From: Laura Gibbons <Laura.Gibbons@arun.gov.uk>
Sent: 15 December 2020 15:01
To: Planning.Responses <Planning.Responses@arun.gov.uk>
Cc: Anita Gardner <Anita.Gardner@arun.gov.uk>
Subject: RE: Planning Consultation on: FG/153/20/DOC

We do not recommend discharge of Condition 2 at this time, and have the following comments:

Application No:	FG/153/20/DOC
Registered:	23rd November 2020
Site Address:	Quercus Nursery Littlehampton Road Ferring BN12 6PG
Description of Works:	Approval of details reserved by condition imposed under ref APP/C3810/W/19/3232525 (FG/35/19/PL) relating to Condition No 2 - surface water drainage.

PROPOSED DRAINAGE LAYOUT
AND DETAILS

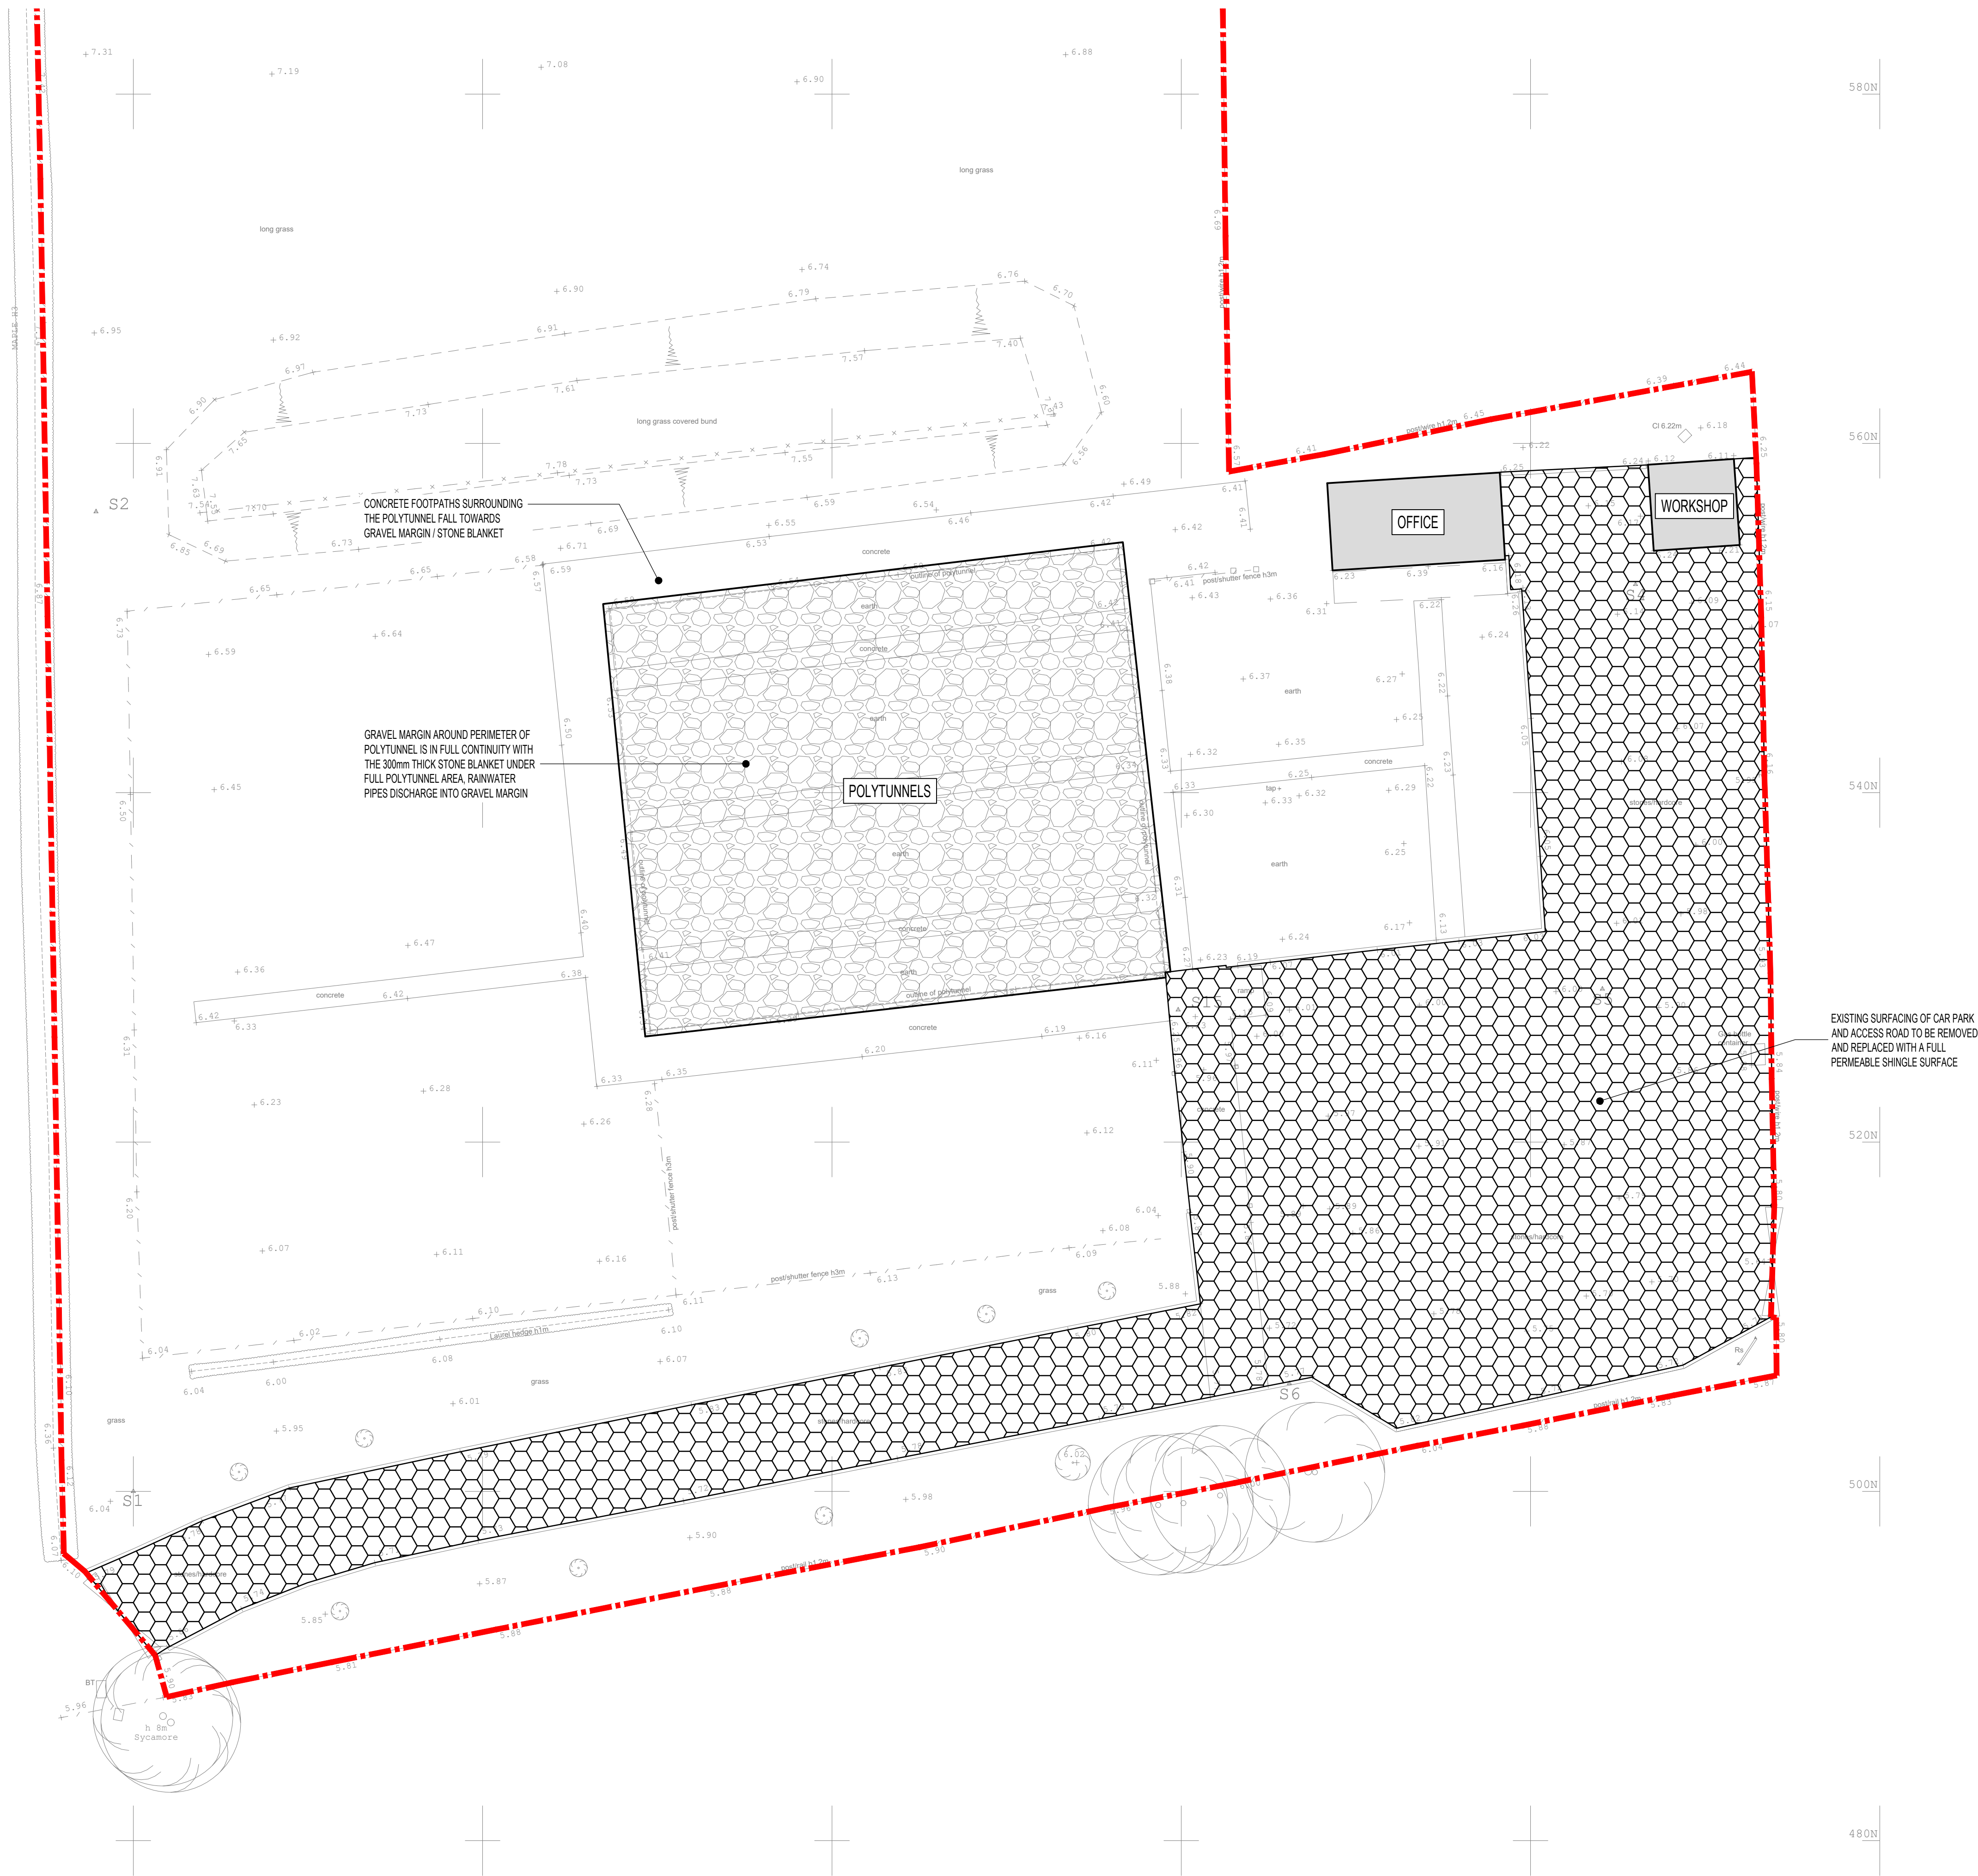
1. Infiltration testing was completed too deep and not in accordance with BRE365. One test was completed in each location only, and water failed to drain to 25% level. The infiltration tests were completed below groundwater level and not at the depth of the proposed infiltrating features.
2. No calculations have been supplied to support the design.
3. No construction detail drawings have been provided.
4. The layout plan does not detail the required depth of the car park sub-base.
5. The layout plan needs to clearly state whether permeable storage areas are to have flat sub-bases or not.
